From: Amanda Scholes on behalf of Planning.Responses
Sent: 19 November 2018 12:26
To: Planning Scanning
Subject: FW: A/99/17/OUT - Land south of Water Lane, Angmering

From: Paul Bicknell [REDACTED]
Sent: 13 November 2018 11:57
To: Karl Roberts; Neil Crowther
Cc: Michael Eastham; Stephen.Gee@westsussex.gov.uk; Cllr. Paul Bicknell
Subject: RE: A/99/17/OUT - Land south of Water Lane, Angmering

I have viewed the links suggested by Cllr Bicknall and do not consider that any of them would be necessary to be provided by the development. The applicant has provided a NMU audit as part of the Transport Assessment (Appendix D- although I don't think it is actually hosted on the portal due to size). I have checked the accident records and no accidents involving pedestrians are shown so the development would not exacerbate any existing safety issues.

TITLE: LAND SOUTH OF WATER LANE,
ANGMERING
WALKING AND CYCLING
CONNECTIONS PLAN

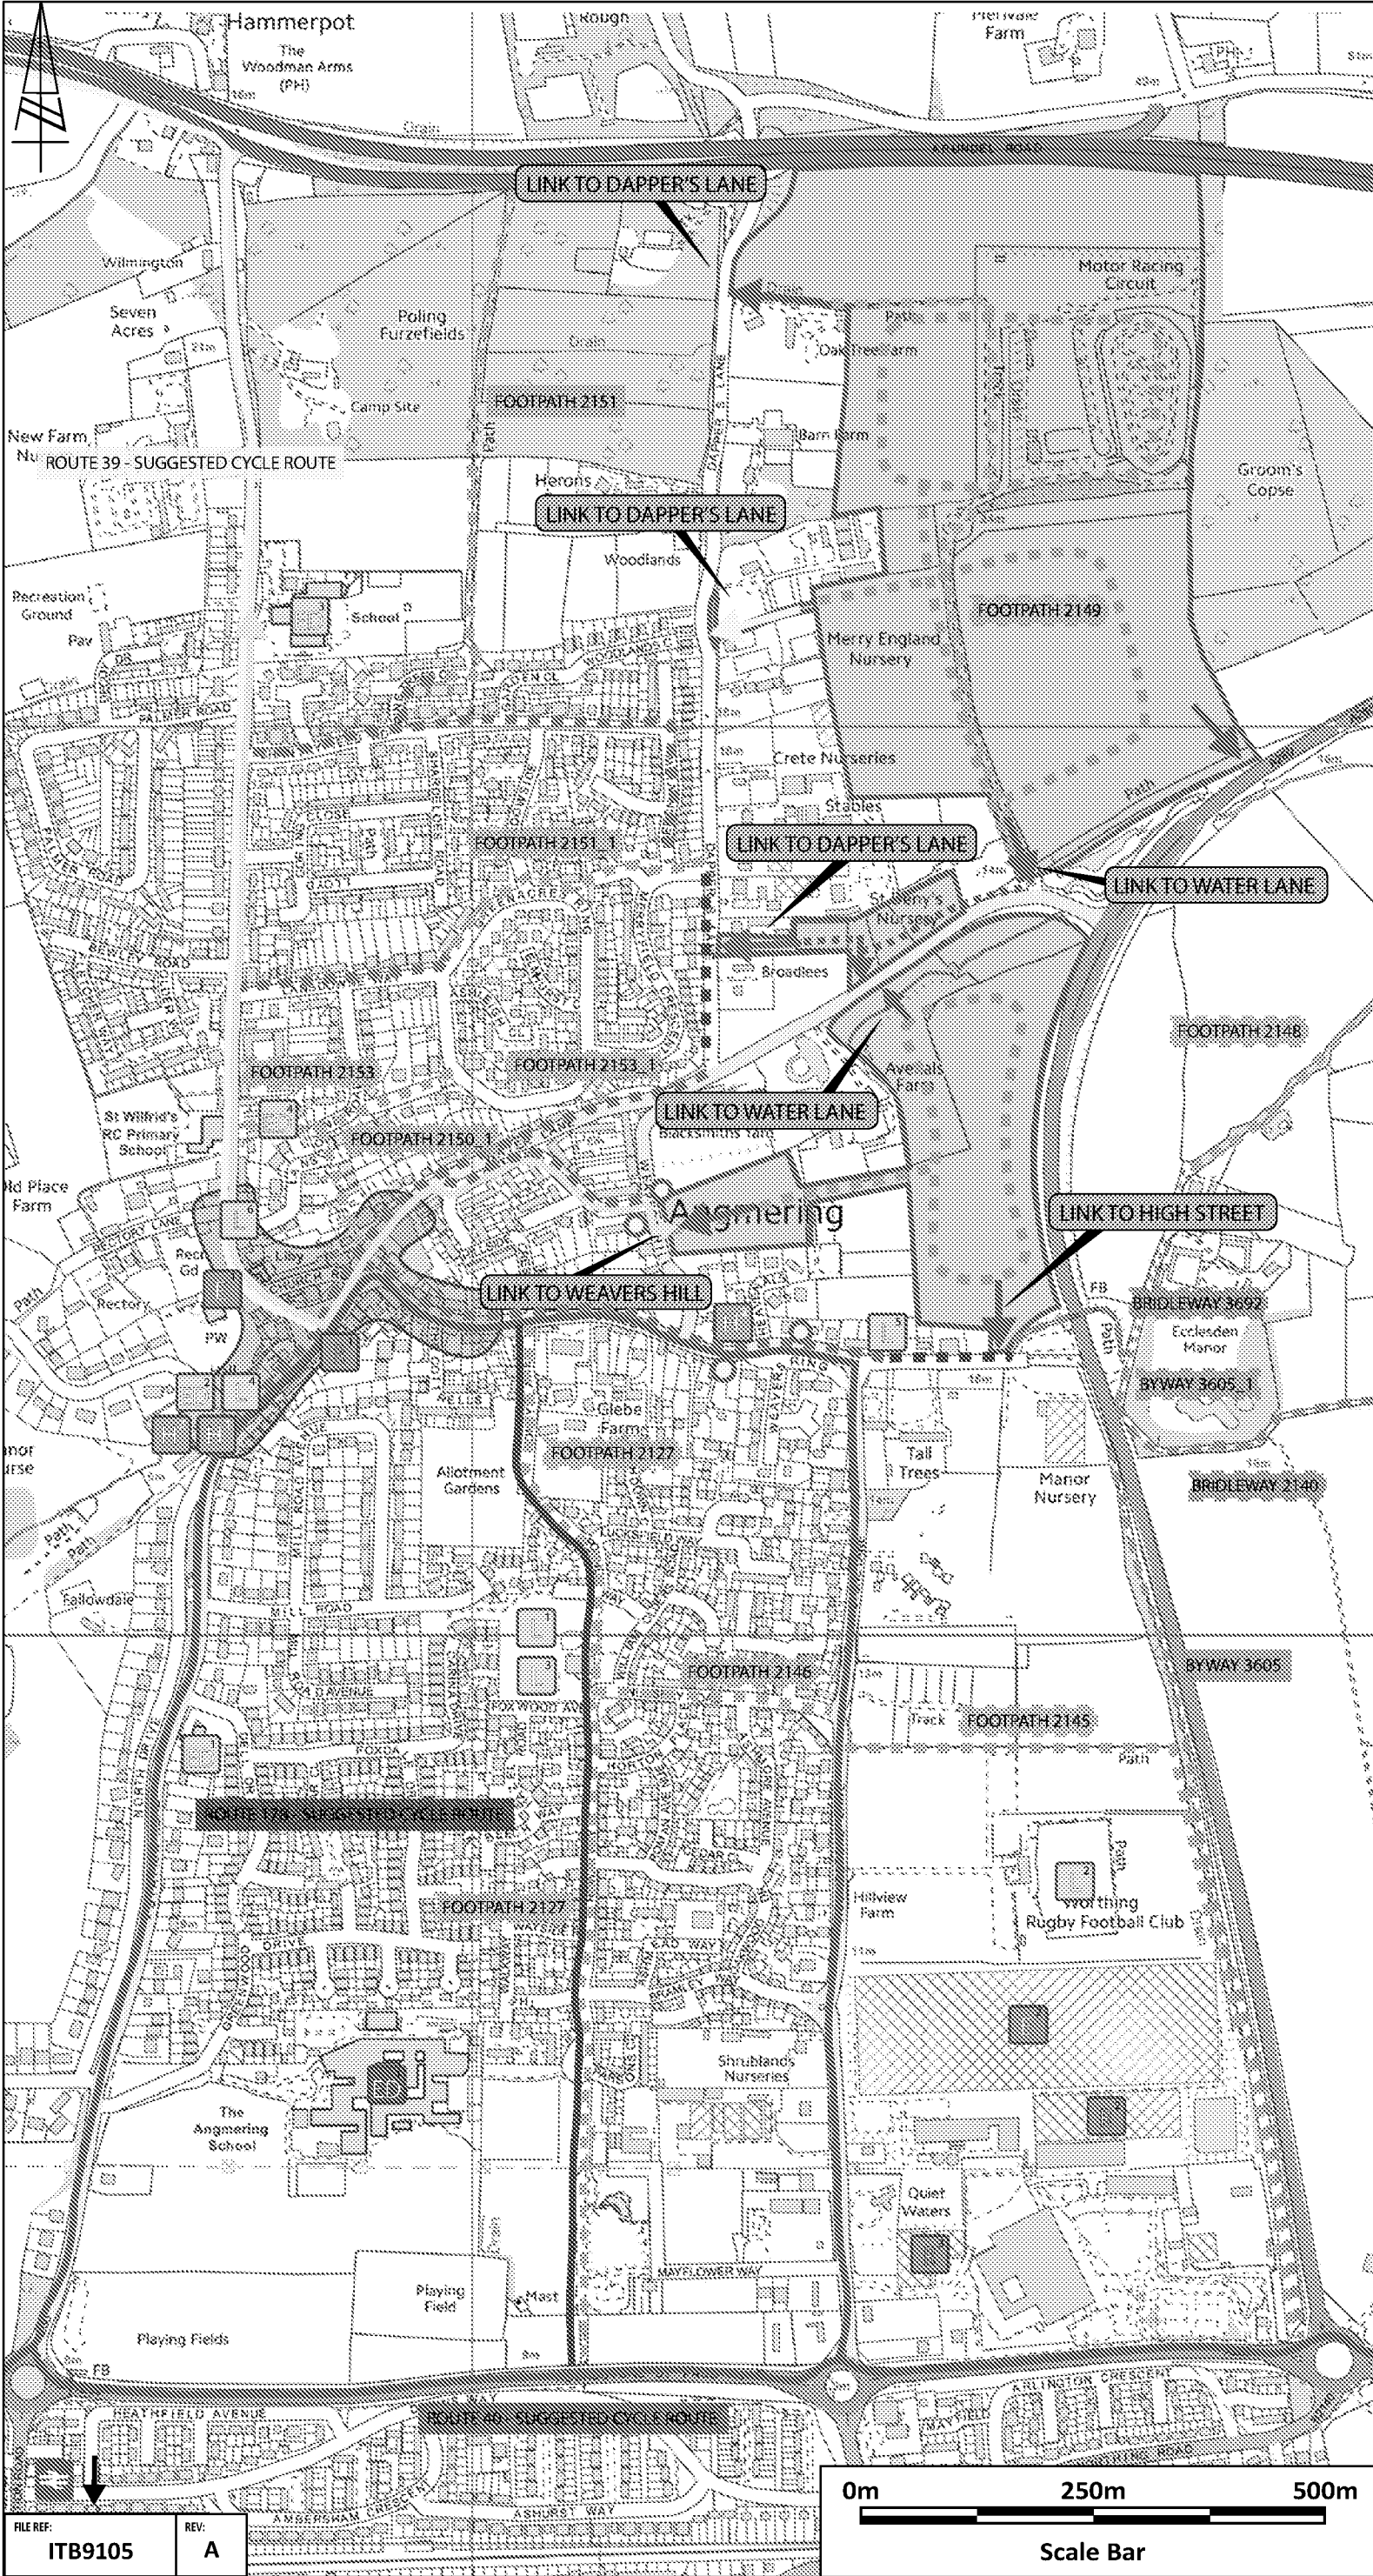
North of the site :- Provision to the east along Water Lane and West via a proposed development access would be secured via A/40/18.

East of the site – The site provides crossing facilities at Weavers Hill to enable pedestrians to cross into Cumberland Drive
Highfield Close has a footway on the northern side of the carriageway and steps provided into the private road of Hillside Crescent
Hillside Crescent--Low vehicle flows and as the road is private even if it were deemed a necessity it would not be possible to request that the applicant upgrades.

Hillside crescent might be a private road but the developer can provide a proper foot path along a private road

Re Honey Lane this suffers the same pedestrian dangers as Hillside crescent as over half of honey lane does not have a safe foot path for pedestrians

Although the road was made up it is now in such a state as to constitute a danger to pedestrians

This development comprises of some 170 dwellings and the shortest route to the Angmering secondary school is along high street and round stone lane
Cow lane is not a preferred route to school

This development could equate to over 400 journeys to / from school per day from an area there are presently Zero journeys to / from school

And as such any infrastructure that might be provided by the Manor Nursery development can not be used for the A/99/17 development

So this also questions your statement and the internal network of the Roundstone Lane developments as this is not connected to the proposed development

North of the site – As identified in my formal response a condition could be placed on the site to ensure delivery of a pedestrian link to Water Lane once the land North of Water Lane site has commenced. Provision to the east along Water Lane and West via a proposed development access would be secured via A/40/18.

East of the site – The site provides crossing facilities at Weavers Hill to enable pedestrians to cross into Cumberland Drive
Highfield Close has a footway on the northern side of the carriageway and steps provided into the private road of Hillside Crescent
Hillside Crescent–Low vehicle flows and as the road is private even if it were deemed a necessity it would not be possible to request that the applicant upgrades.
Honey Lane – Low vehicle flows and again a private route but with existing footpath status is along the route

- High Street – Improvements are proposed as part of the manor Nursery Application – Until such a time the development is commenced, vehicle flows along this section of the high street would not require the provision of a formal pedestrian provision.
- Roundstone Lane –Pedestrian provision is provided the length of Roundstone Lane, Cow Lane and the internal network of the Roundstone Lane developments also provide alternative southbound provision. It is acknowledged that pedestrians would be required to cross into Weavers Ring to utilise the footpath to avoid walking in Roundstone Lane for a short section however this is an existing constraint and would be addressed by the implementation of Manor Nursery or as advised above alternative routes are available.
